4 May 2009

**RE: MP08\_0014 – PROPOSED RESIDENTIAL SUBDIVISION, MORISSET PARK**

We have provided below a response to the various issues raised by the Department of Planning (“DOP”) in their letter dated 9 February 2009. Our response is supported by the following plans and documents:

STORMWATER DETENTION BASIN PLAN

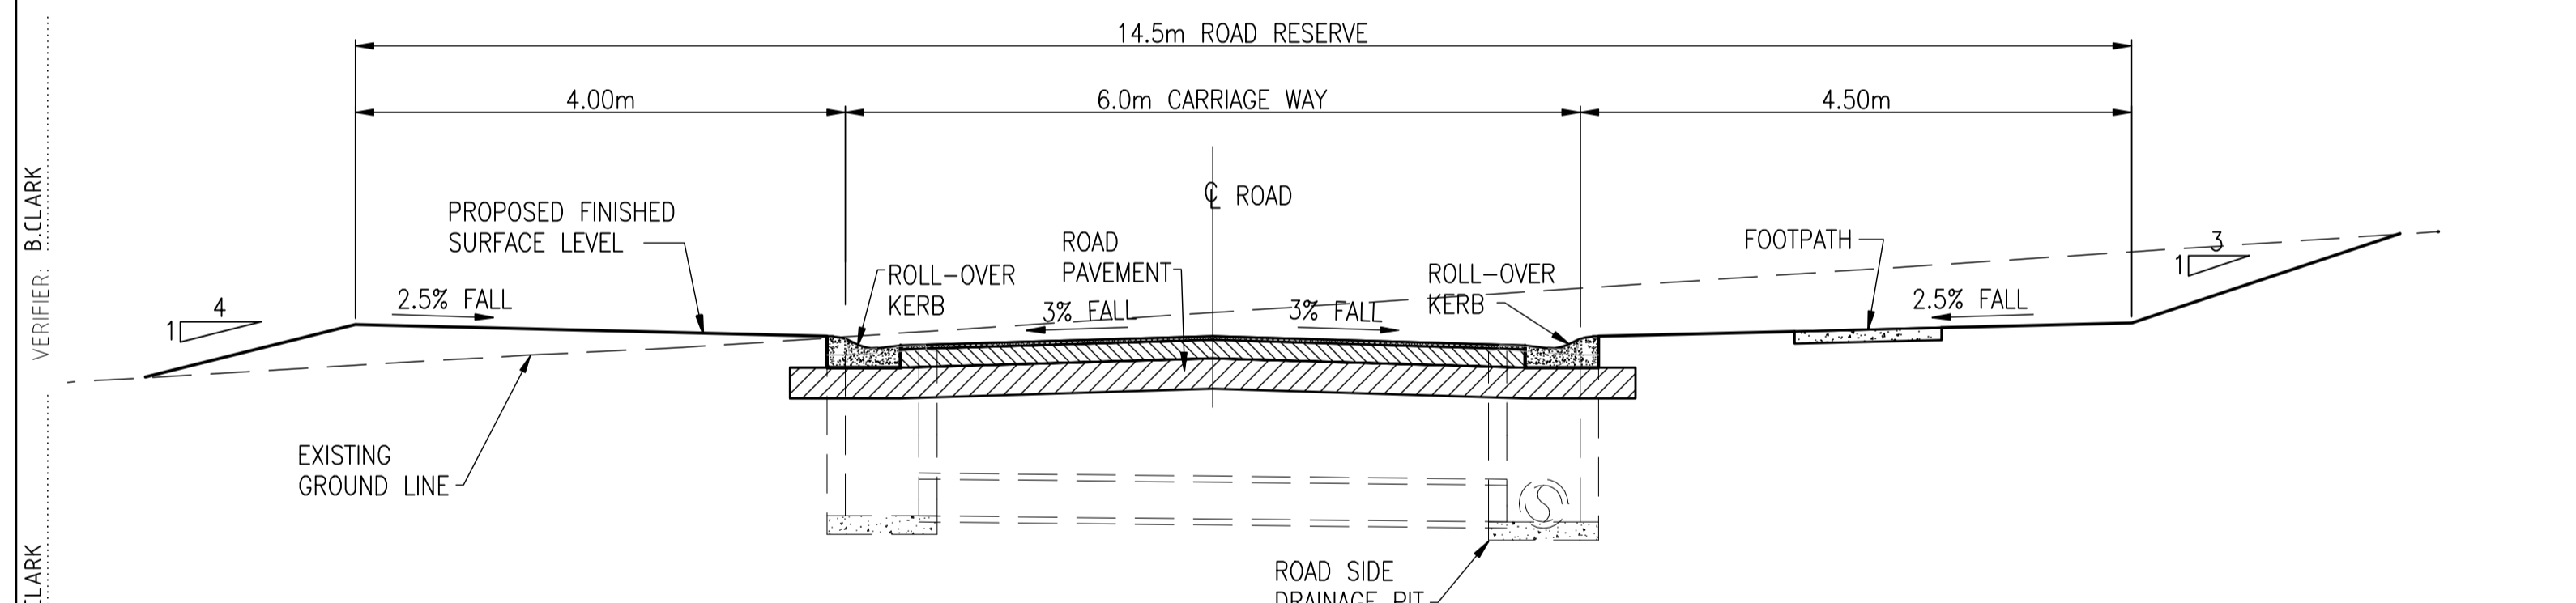
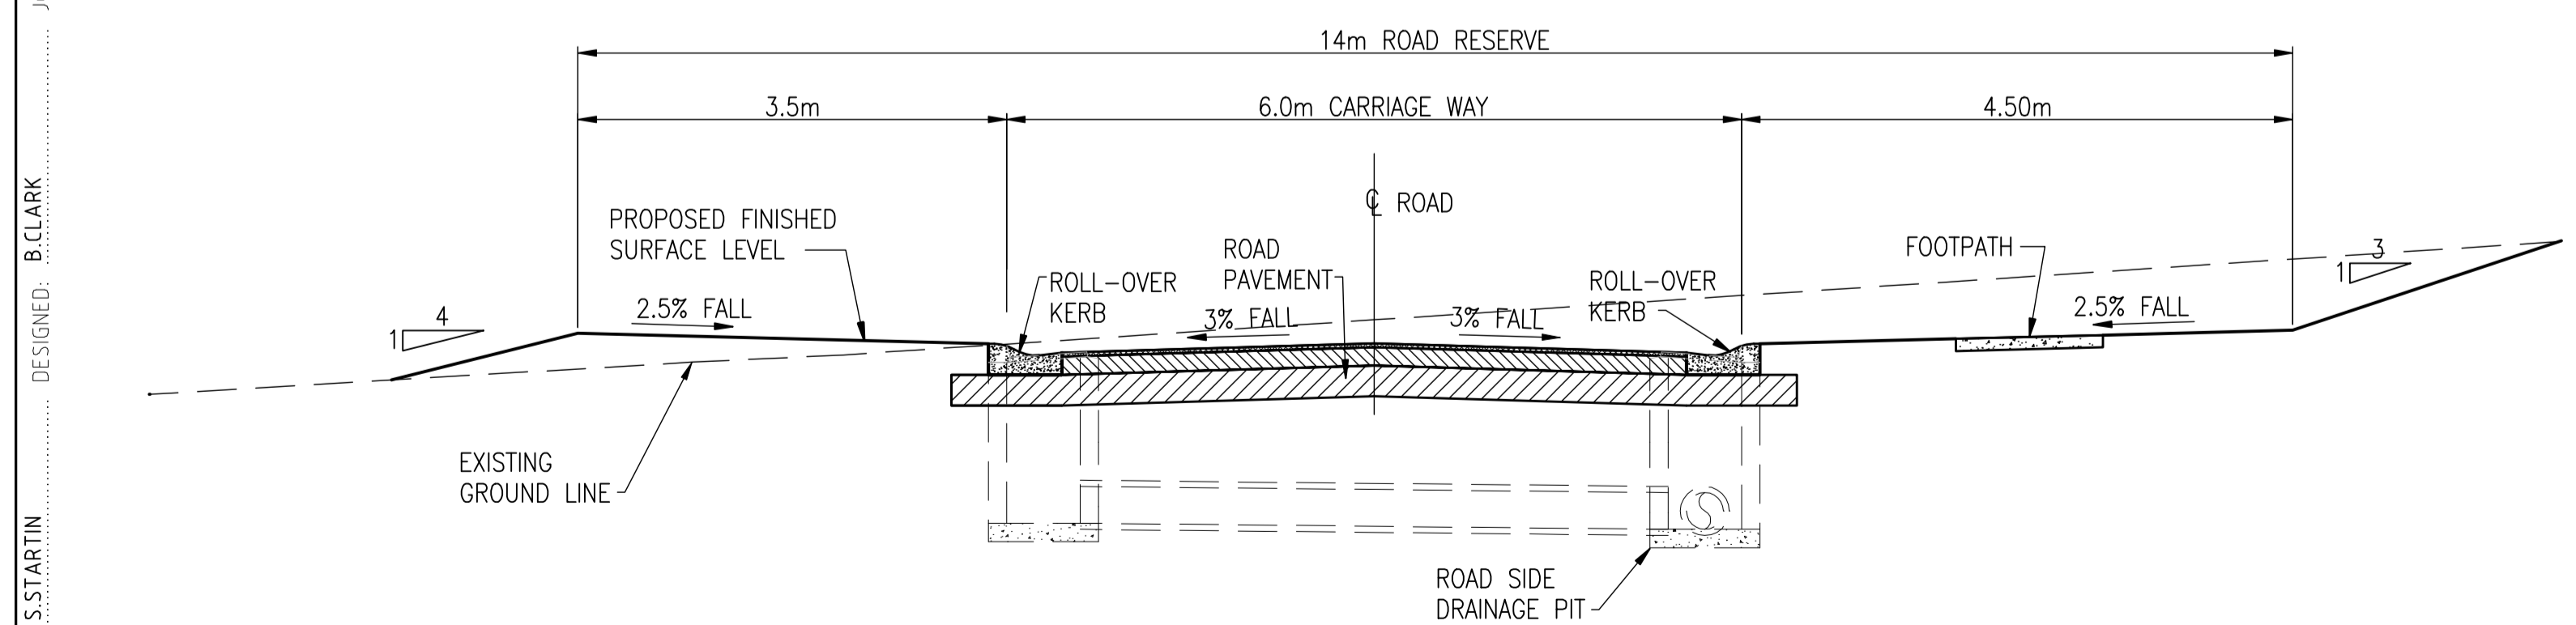
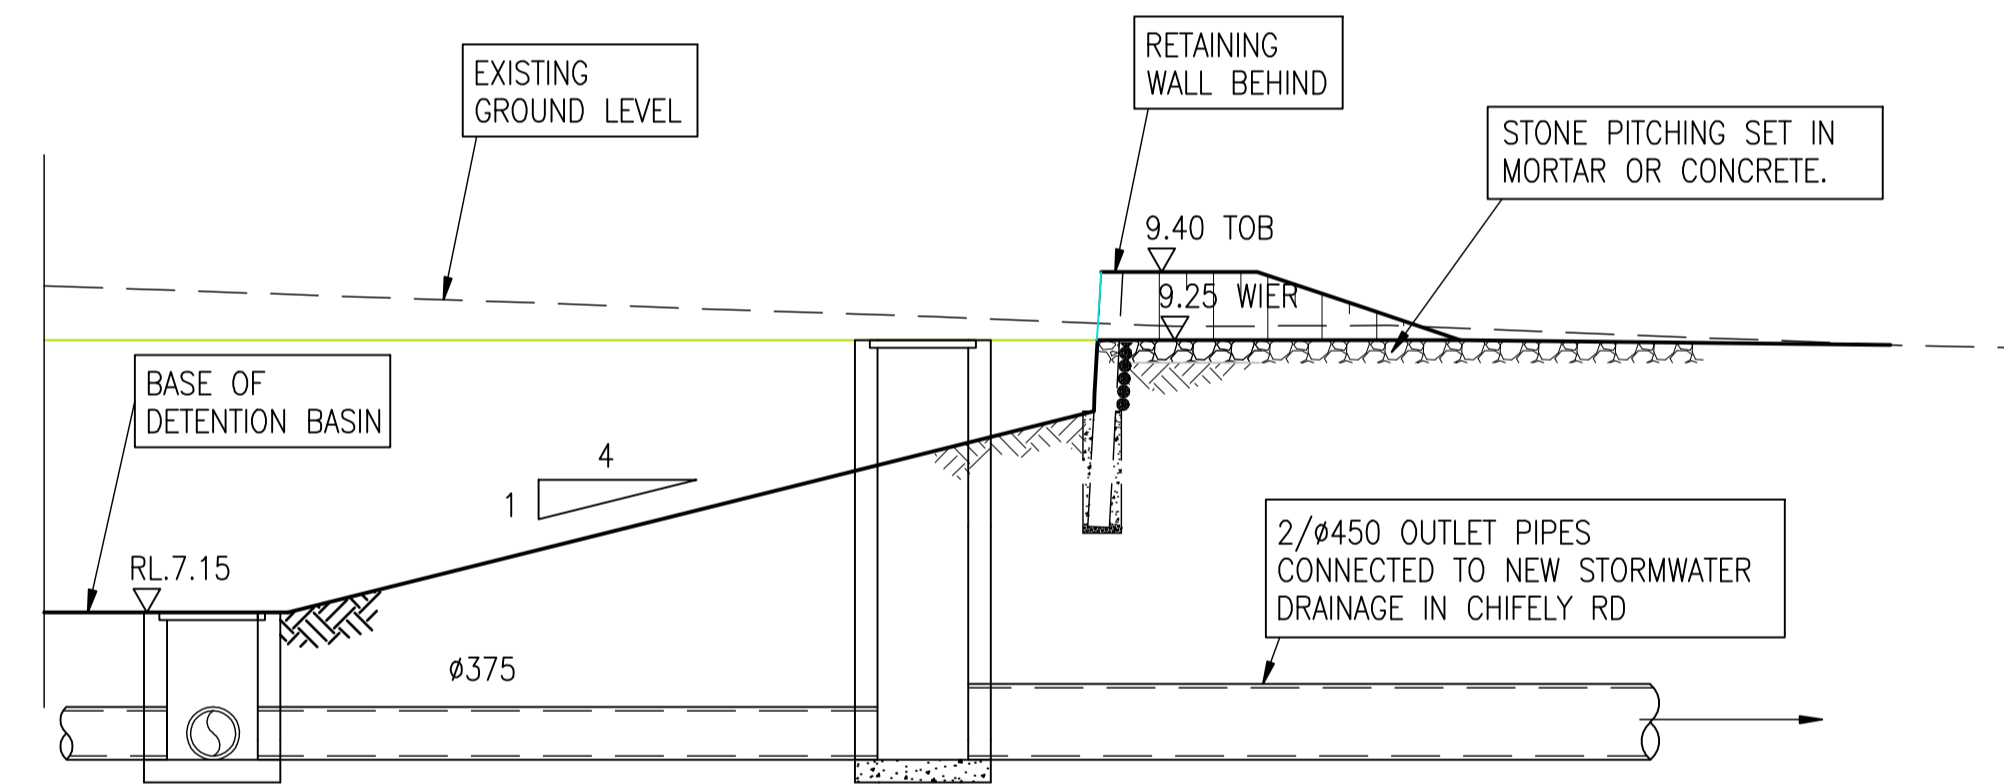
- The redesign of the outlet from the detention basin, including a new pit to take high level flows directly to the weir and the resizing of the outlet pipes to cater for the 1 in 100 year flow.

- The revision of the internal batters of the detention basin to be a maximum slope of 1V:4H to cater for Council maintenance requirements.
3. An amendment to the existing easement to ensure Lot 358 DP 755242 is benefitted by the easement over lot 2 DP 244002. These terms are being finalised with the owners of Lot 2 DP 244002 (see letter from Armstrongs Solicitors Pty Ltd dated 7 April 2009 in Appendix 4).
